Recommendation Report for Planning Permission

REF NO: FG/105/20/PL

LOCATION: The Tudor Close Public House
Ferringham Lane
Ferring
BN12 5NQ

PROPOSAL: Conversion of existing Public House (Use Class A4) to create 7 No residential units comprising 5 No 1-bedroom units & 2 No 2-bedroom units & the erection of 2 No 1-bedroom semi-detached bungalows, associated car parking & landscaping (resubmission following FG/46/20/PL). This application affects a Public Right of Way & is in CIL Zone 4, CIL Liable for new dwellings.

Drawing Title:
**Roof Plan
As Existing
As Proposed**

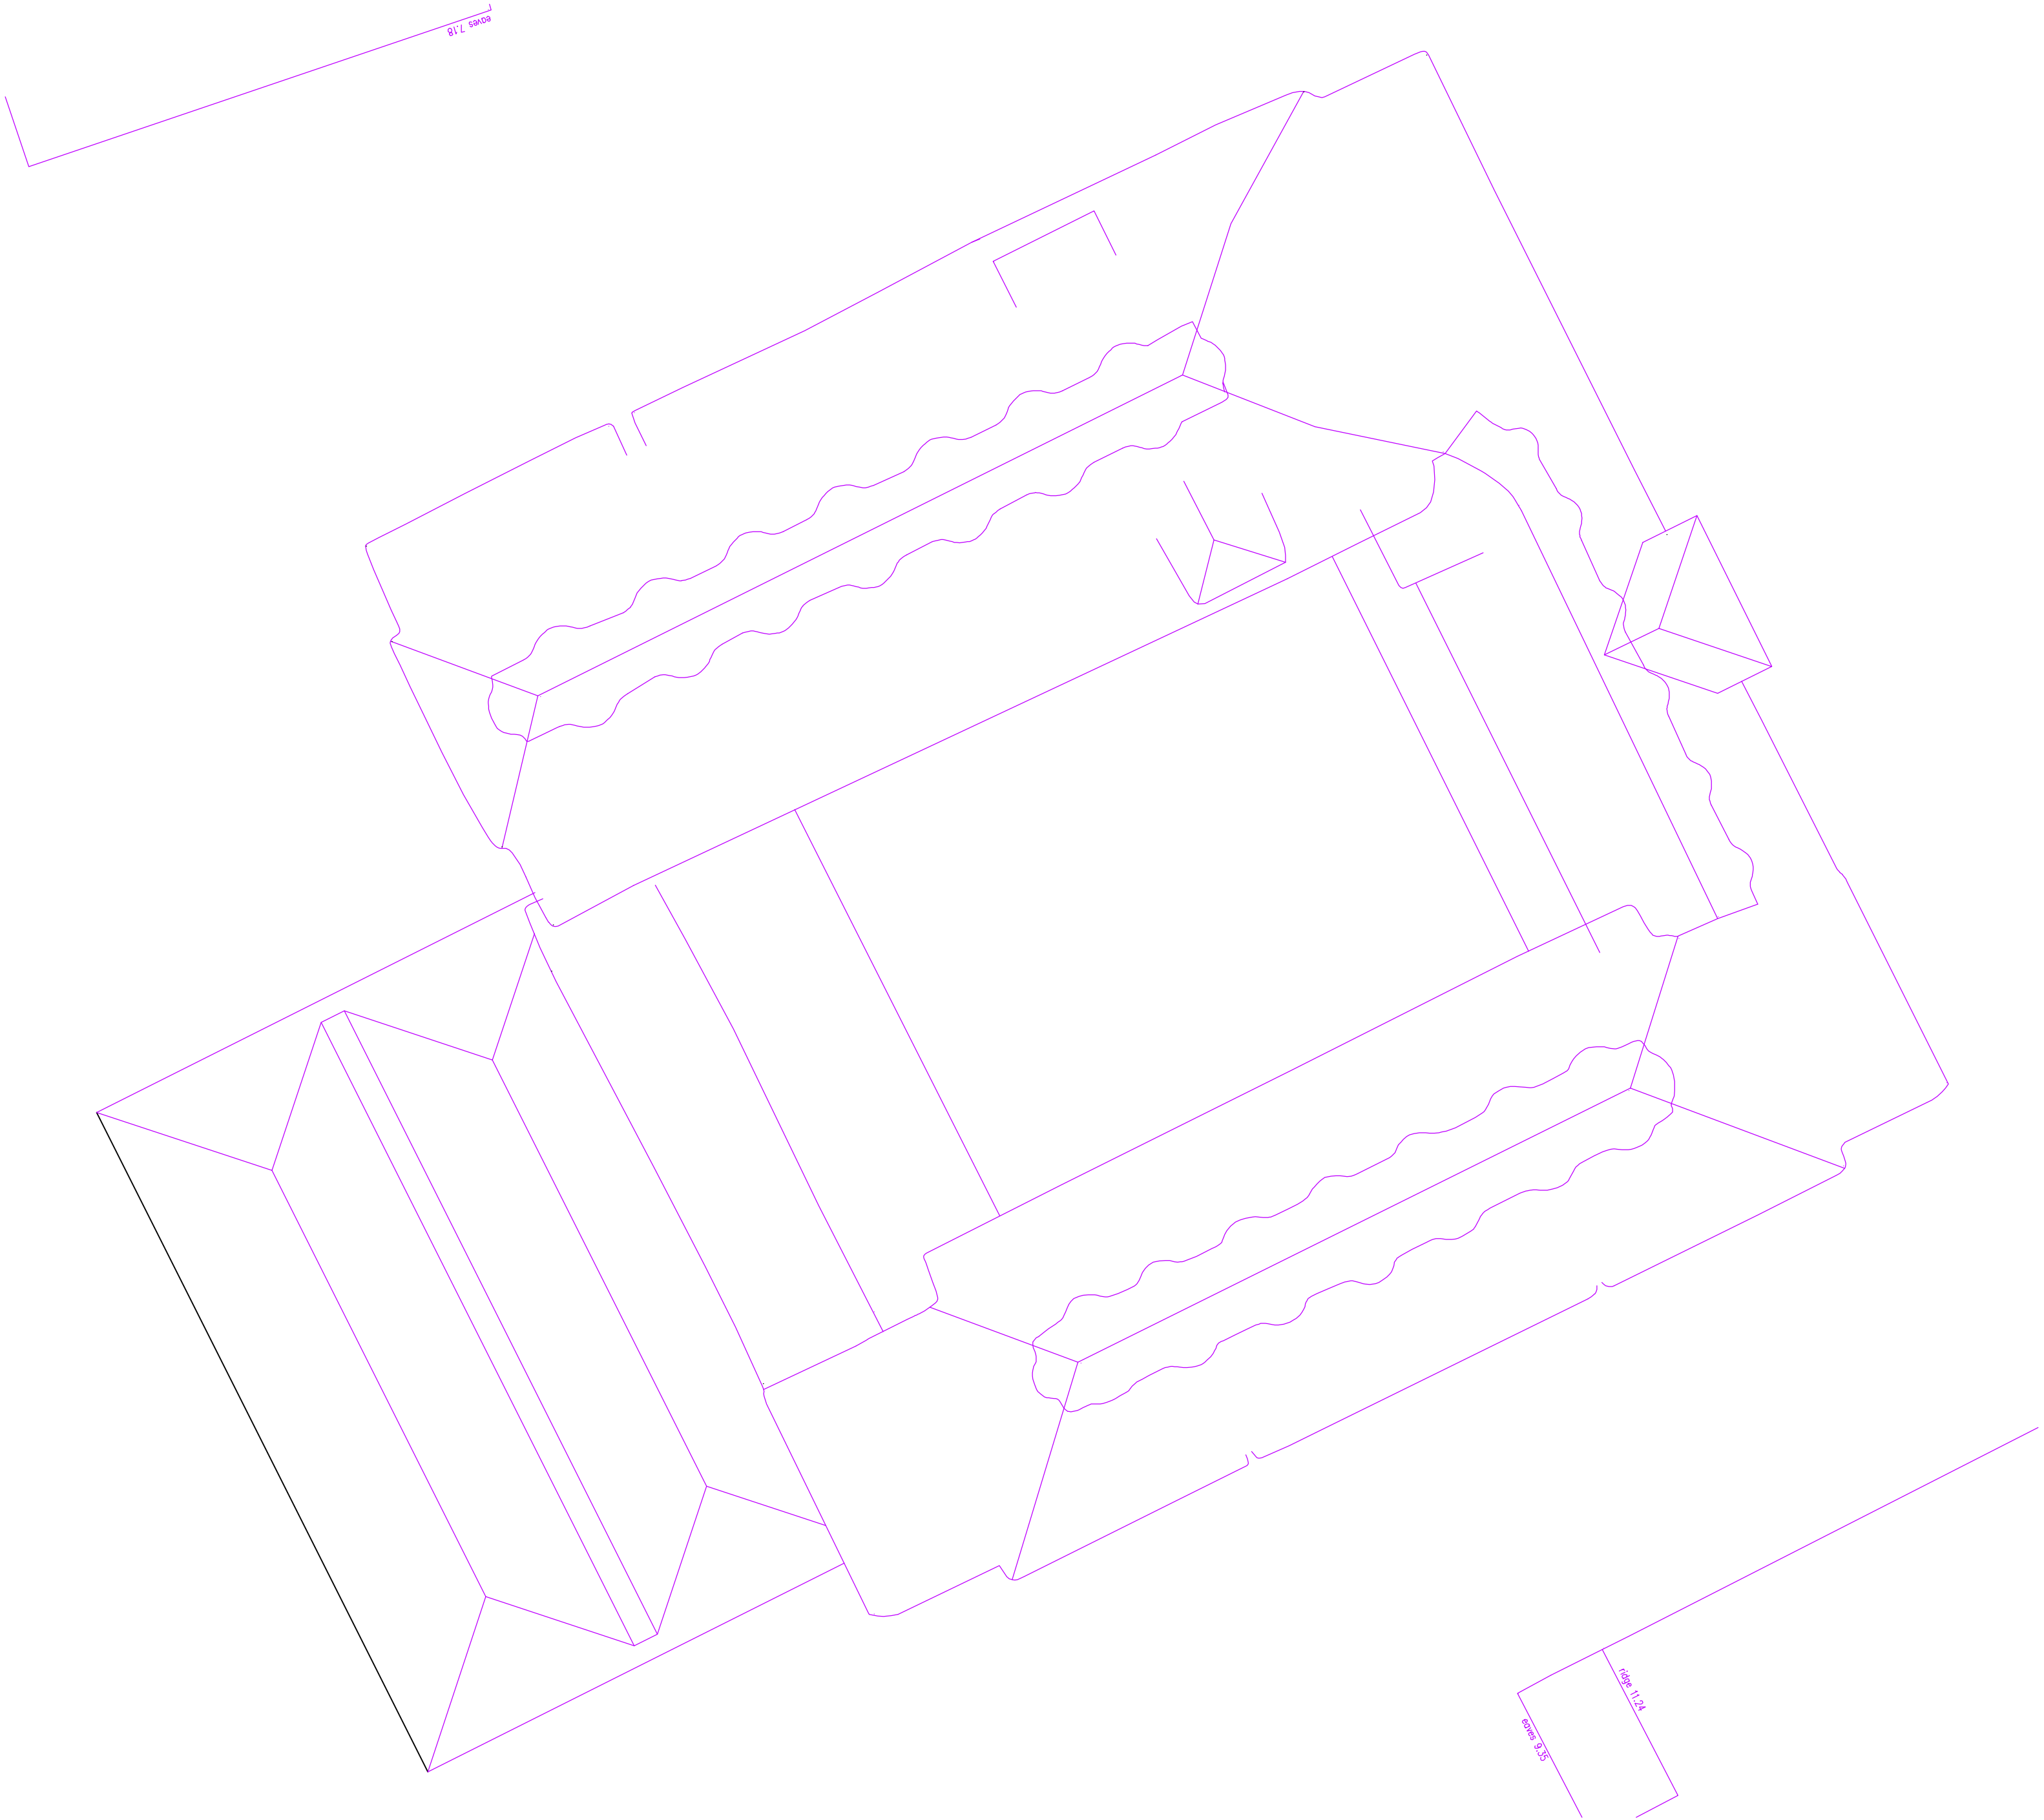
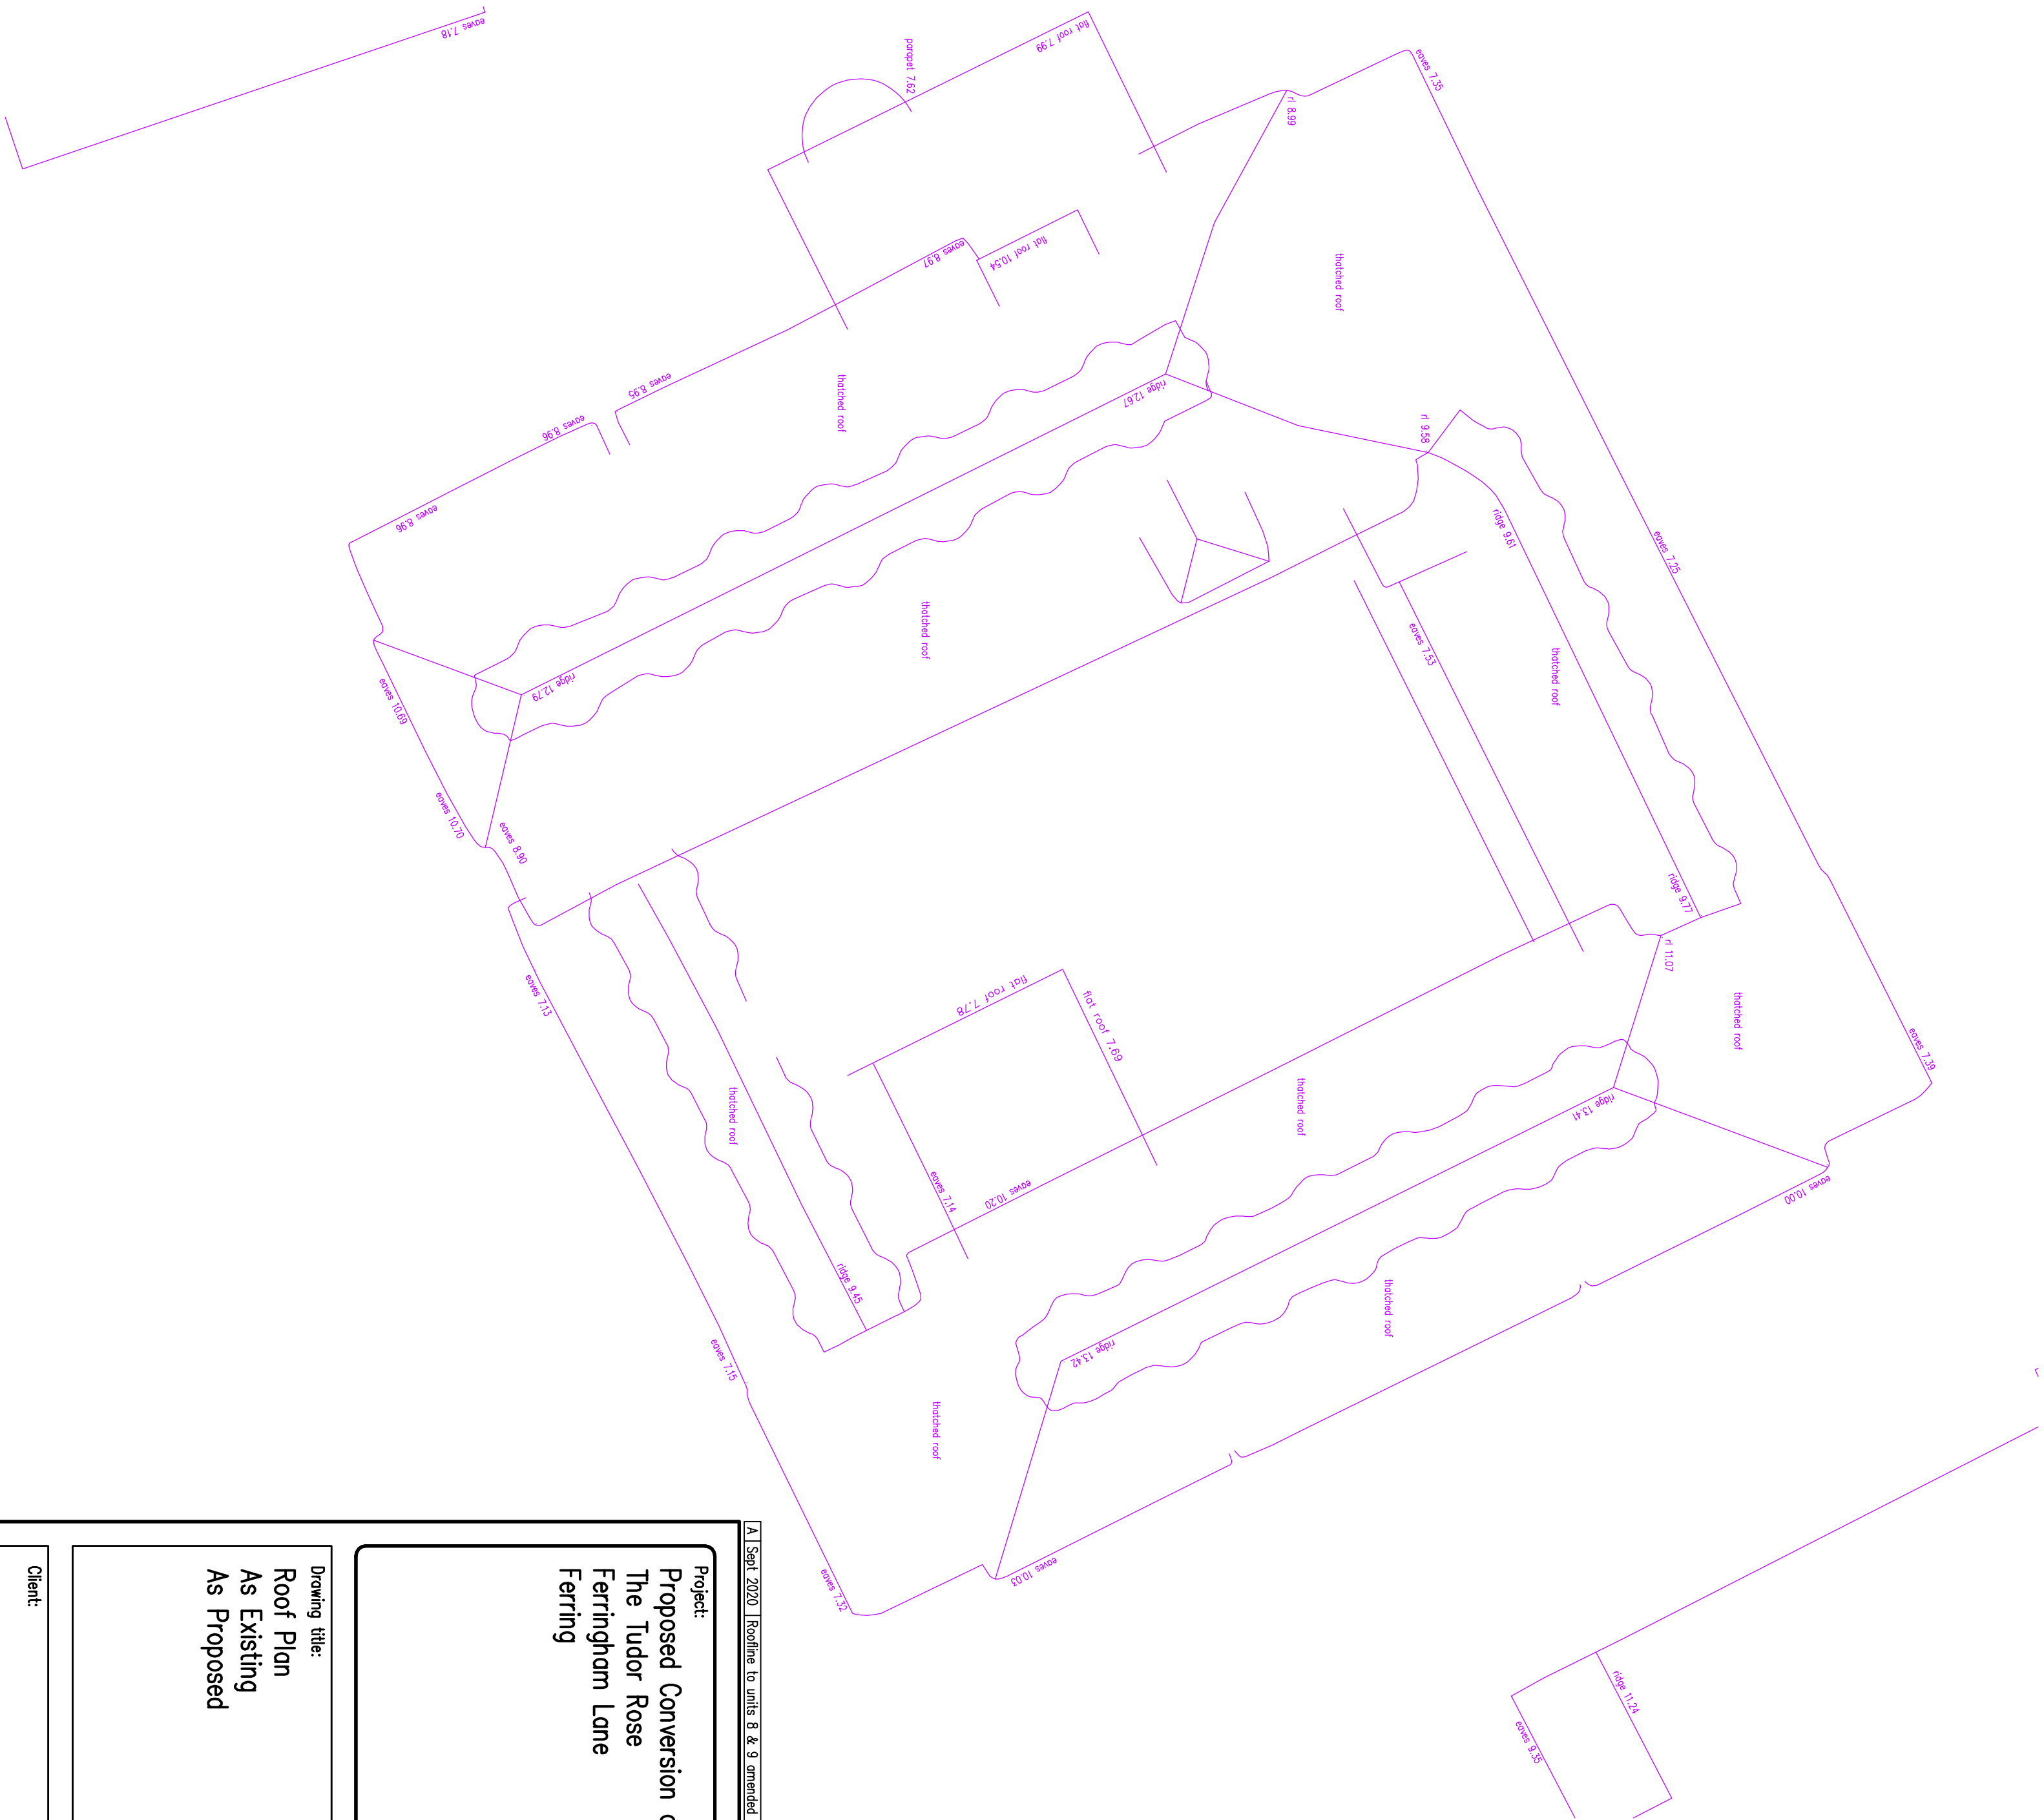
Given the limited fenestration changes the conversion of the existing building is considered to be acceptable. The extension to add two bungalows to the rear of the property is considered an acceptable addition being one storey in height well below the roof line of the main building. The proposed pitched roofs of the single storey bungalows would be visually integrated and subservient to the design of the existing building in accordance with policy D DM4 of the ALP.

The development is acceptable in terms of having a limited impact on the building as a whole as a result of the extension to the rear being single storey which means the new roof would not be visible from the street giving the building an acceptable appearance.

Appendix 2: Proposed Elevations

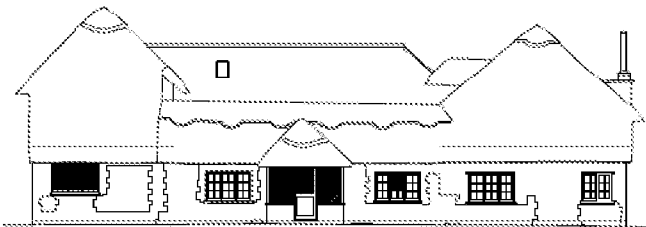
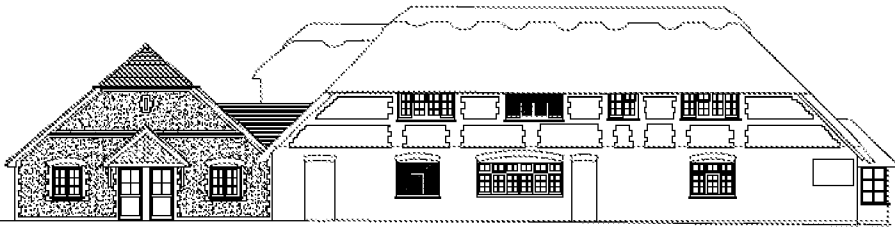
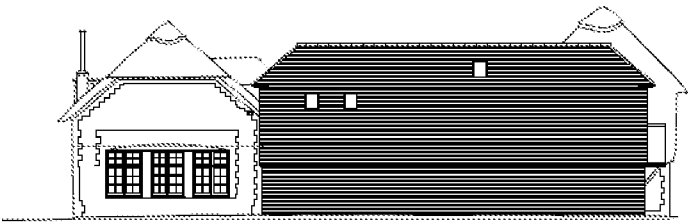
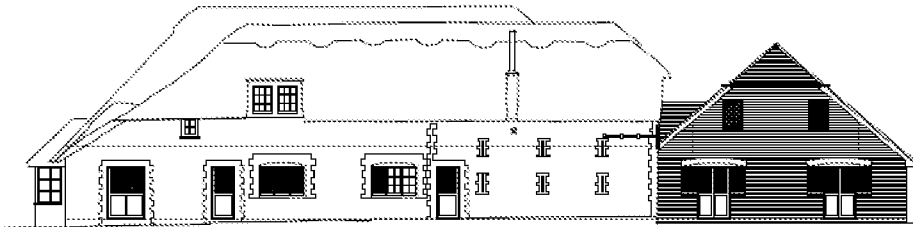
There is the issue of bedroom/sitting room and landing windows along the west elevation of flat 6 overlooking the private, external ground floor communal space for flats 3,4,5,6, and 7. However, there are east elevation windows which could compensate for any loss of light/ventilation from making these windows fixed shut and glazed to avoid any unacceptable overlooking of this private amenity space.

There are also sole west elevation first floor bedroom windows to flat 1 which overlooks the front of 12 Ferringham Lane. These windows provide direct views towards the front amenity space to 12 Ferringham Lane at a distance less than 20m away. This is an existing window which overlooks a part of 12 Ferringham Lane where you would not expect it to be used as private amenity space.

- 7 The windows on the west elevation of the flat 6 shall at all times be glazed with obscured glass and fixed to be permanently non-opening up to 1.7 meter above finished floor level.
